DRB Application No.: 07DRB-70096 (P&F)
Project Name LANDS OF RAYCO
Agent: JACK'S HIGH COUNTRY INC

CITY OF ALBUQUERQUE
Planning Department
October 3, 2007
DRB COMMENTS

RE: Tract 1-A & 2-A, Lands of Rayco/p&f

DEVELOPMENT REVIEW BOARD – SPEED MEMO

PLAT OF TRACTS 1-A-1 AND 2-A-1 LANDS OF RAYCO

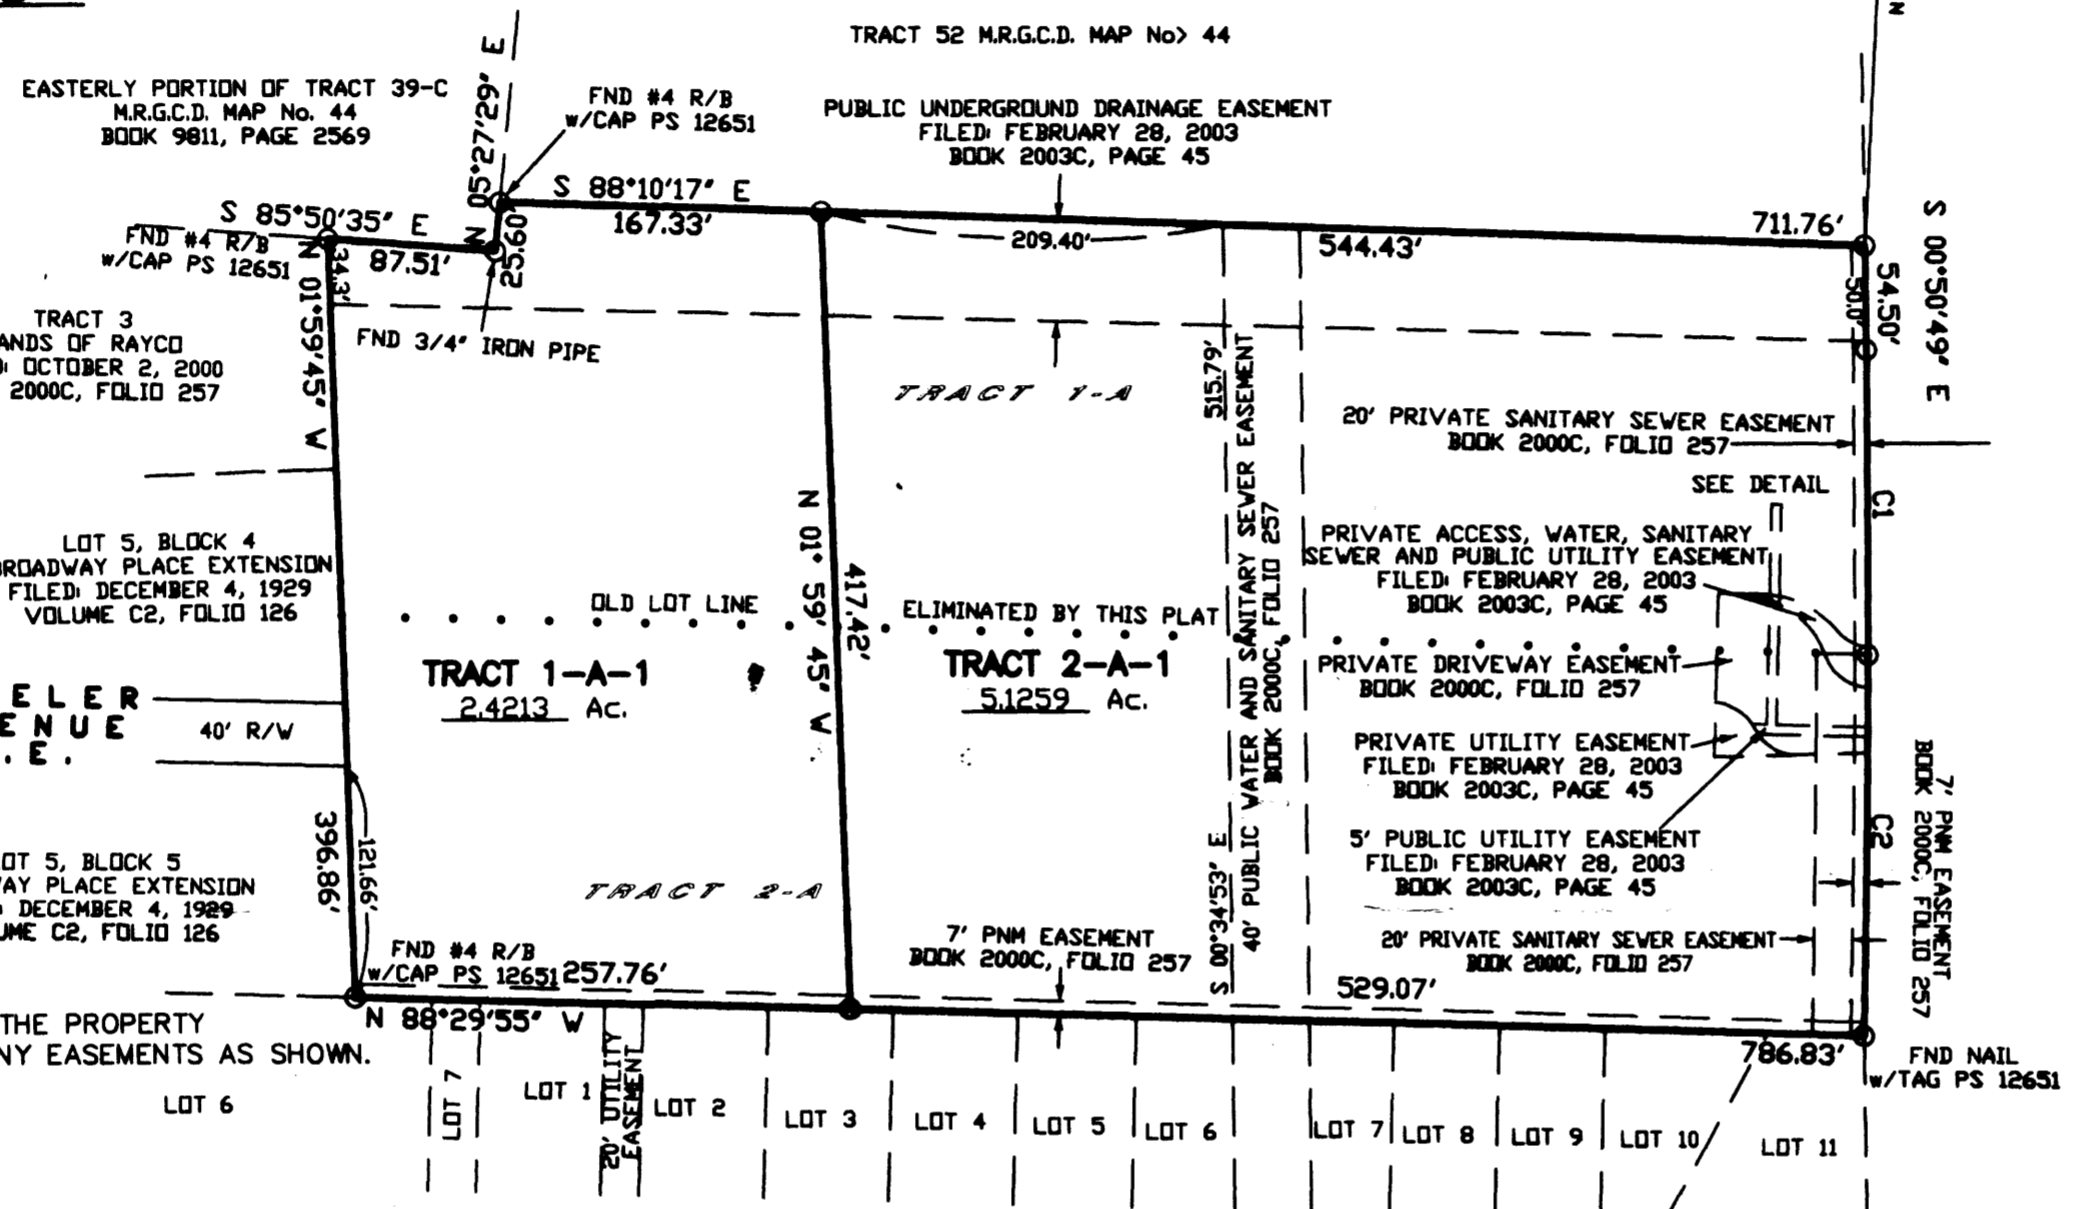
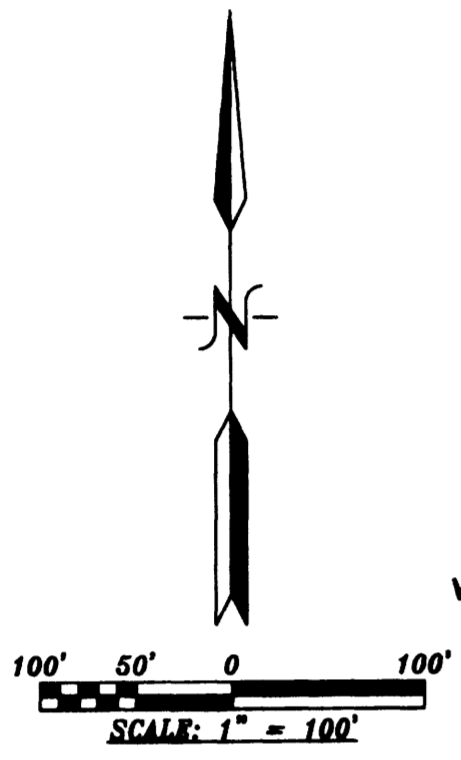
Per Bill No. F/S O-07-72, An archeological Survey is required for sites that are 5 acres or more.

Please be advised that any plats approved by DRB must contain the following language per the City Subdivision Ordinance:

Section 14-14-4-7(B) "No property within the area of requested final action shall at any time be subject to a deed restriction, covenant, or building agreement prohibiting solar collectors from being installed on buildings or erected on the lots or parcels within the area of proposed plat. The foregoing requirement shall be a condition to approval of this plat or site development plan for subdivision."

The AGIS dxf is not approved.

An approved infrastructure list is required for Preliminary Plat approval.
Plat comments.

Planning will take delegation for the solar language, AGIS dxf approval, and to record the plat.

Planning will take delegation for the AGIS dxf approval, and to record the plat.
